Please ask for: Nicola Moore
Email: nicola.moore@arun.gov.uk
Telephone: Ext 37944
Our Ref: FG/144/21/NMA
Your Ref:
Date: 11th August 2021

Application for a Non-Material Amendment Following a Grant of Planning Permission

Development: Non-material amendment following grant of FG/50/21/PL for - Plot 1 - Amendments to front elevation; Plot 2 - Amendments to front elevation, timber boarding has been added to the front elevation and Plot 4 - Amendments to garage design, area of cladding adjacent to the garage doors changed from timber boarding to stacked slate cladding to match the front elevation of the house.

Location: Paddock House 44 Ferringham Lane Ferring BN12 5LU

JOB NO.	DRAWING NO.	REVISION
2007	2.01	D

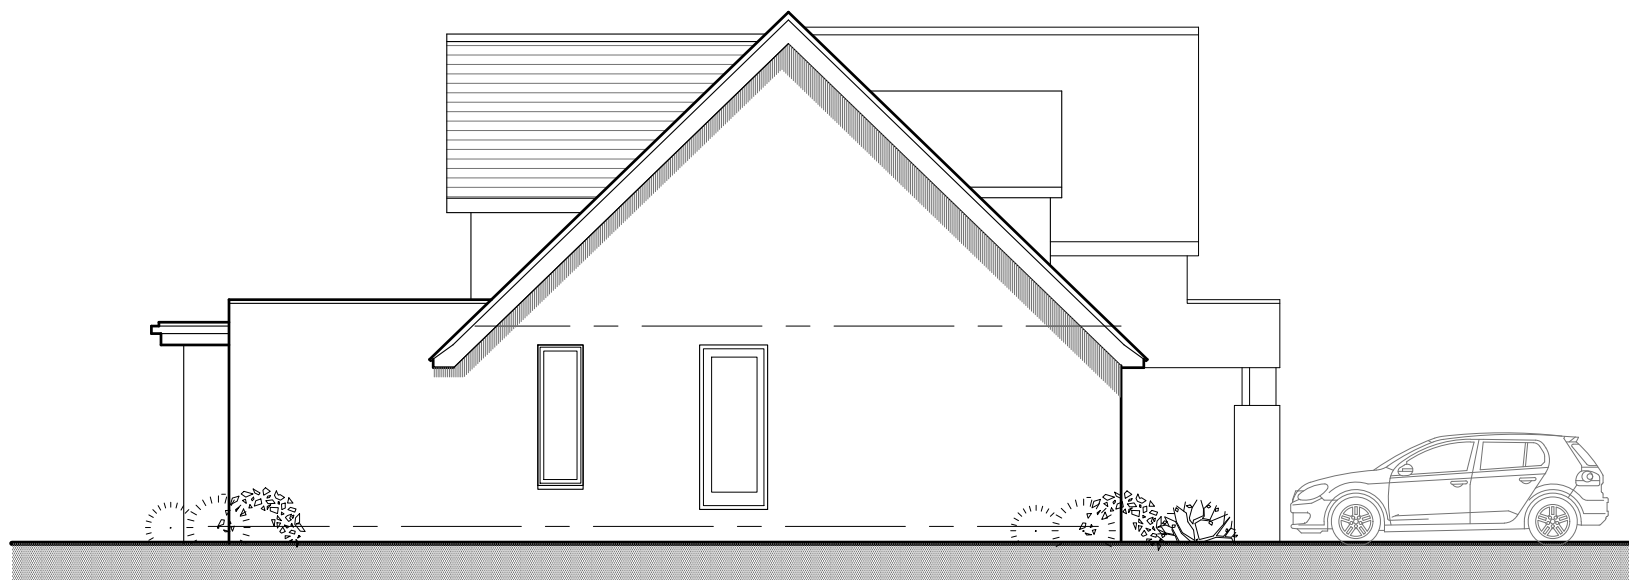
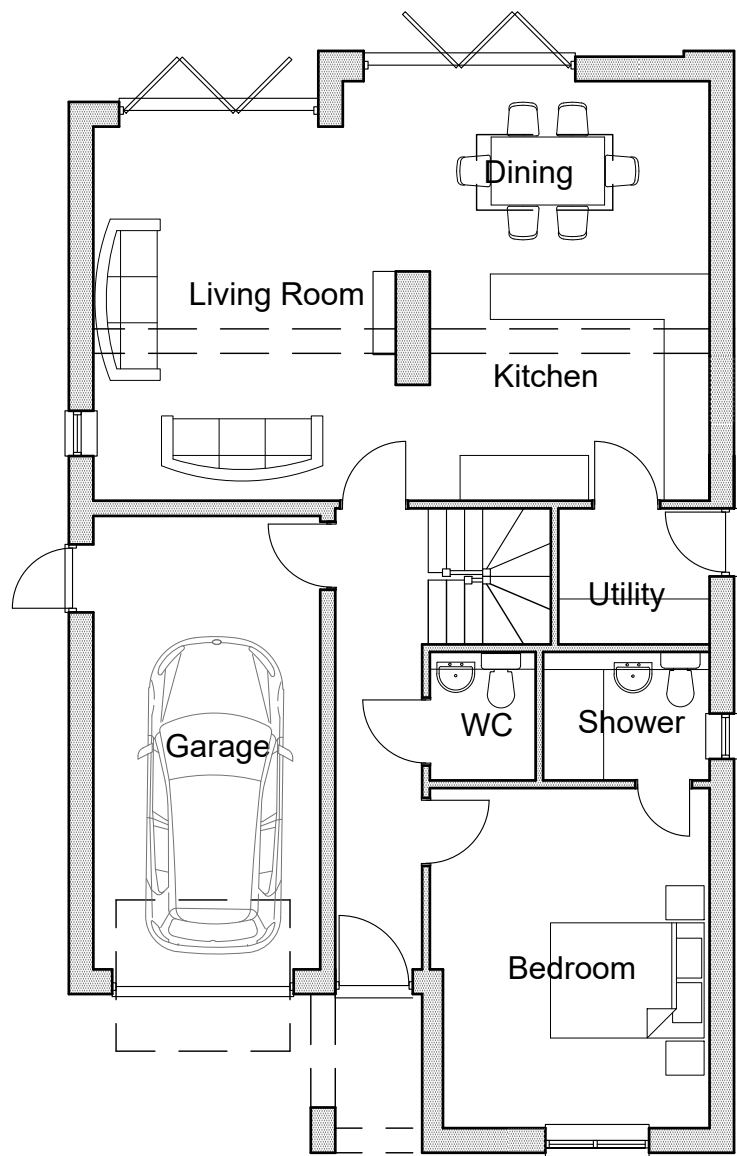
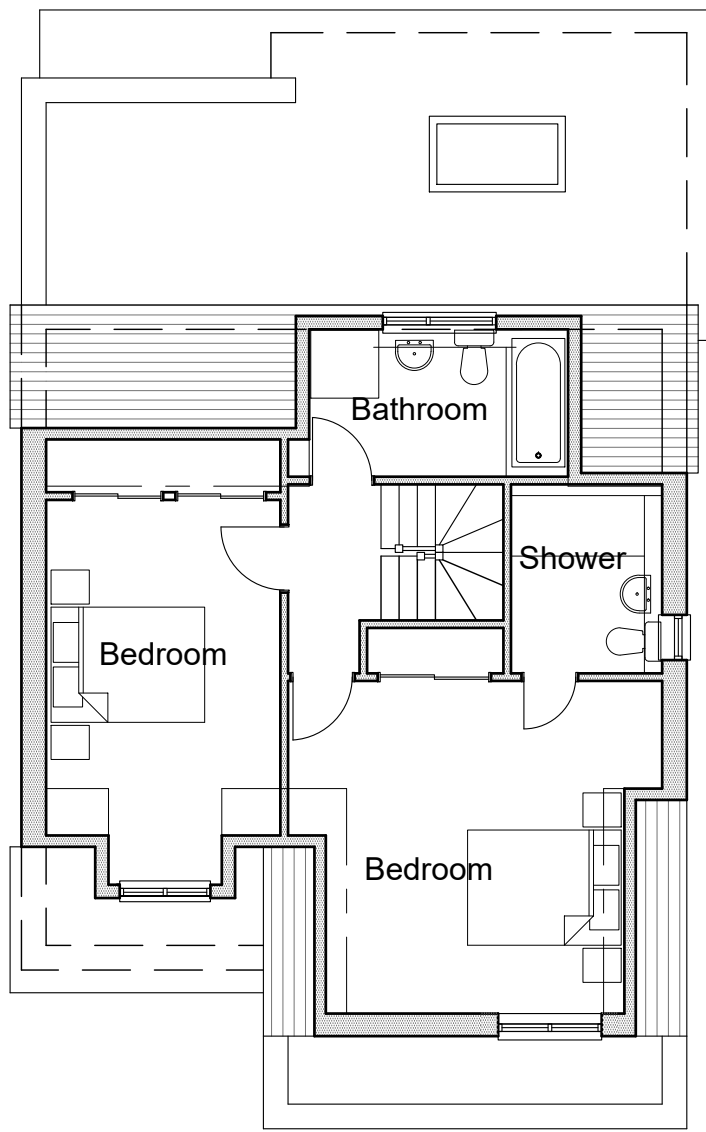
The windows on Plot 1 West Elevation (Dwg No 2.01 Rev C) do not accord. On the floor plans they measure 1.6m, and on the elevations 1.3m. Please amend accordingly and re submit.
